11 August 2022

Pre-application Advice

HELMINGHAM HALL, SUFFOLK – WORKS TO THE HALL

Ben Pentreath		3 Lamp Office Court Lambs Conduit Street London WC1N 3NF T +44 (0) 20 7430 2424 benpentreath.com
PROJECT:	HELMINGHAM HALL	
TITLE:	PROPOSED BOOT ROOM SCREEN DETAILS	
DRAWING NO: A-103.5	REV. NO:	P1
SCALE:	1:1@A1 1:2@A3	DRAWN BY: AM
DATE:	08.11.22	CHECKED BY: RJC

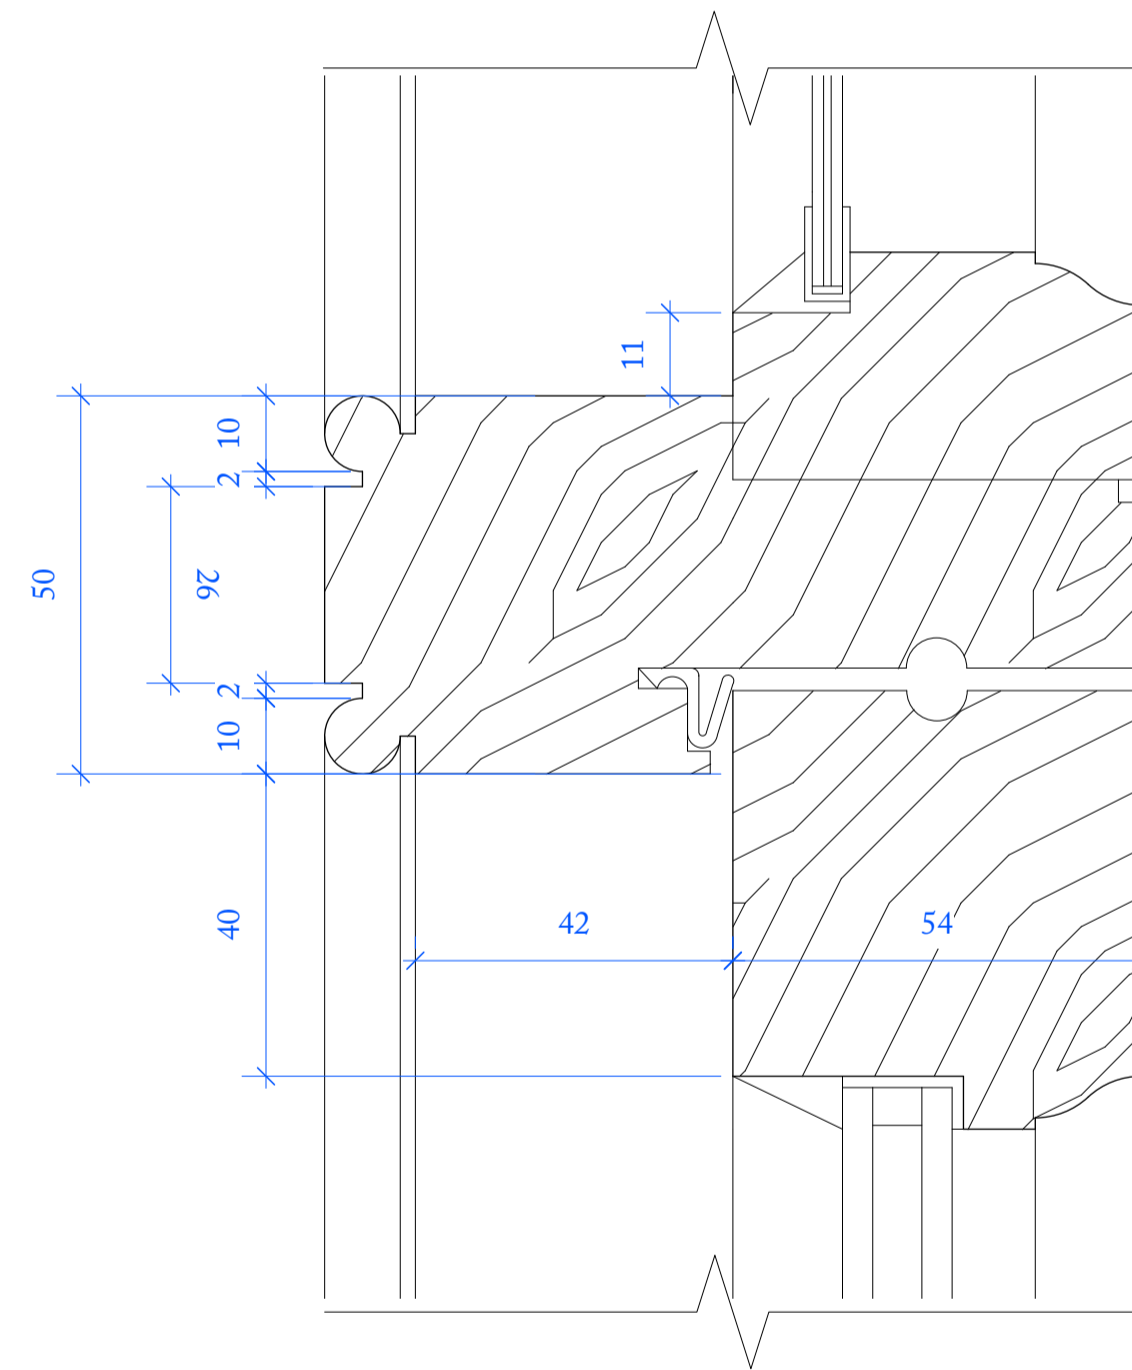
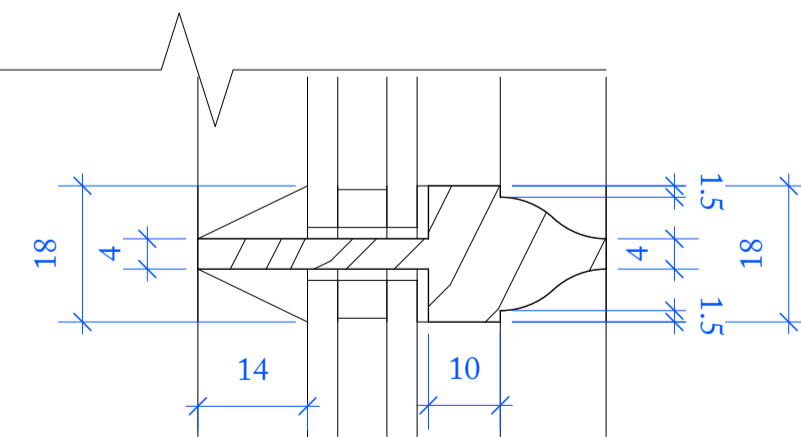
This element of work has been the subject of a large amount of discussion. Although this portion of the building seems to be later, there is evidence that this entrance has seen a lot of use, the floor is charmingly worn through the impact of generations of feet. Earlier proposals showed the floor and walls covered over, it is now heartening to see the floor left as existing. The design of the screen has been designed to mimic that of the door behind and placing it on the inside of the arch means that the frame will be barely visible. Although this is placed within another popular public viewpoint, the amount of glass and the style of the door, which mimics other doors on other elevations, means that the visual harm would be minimal.
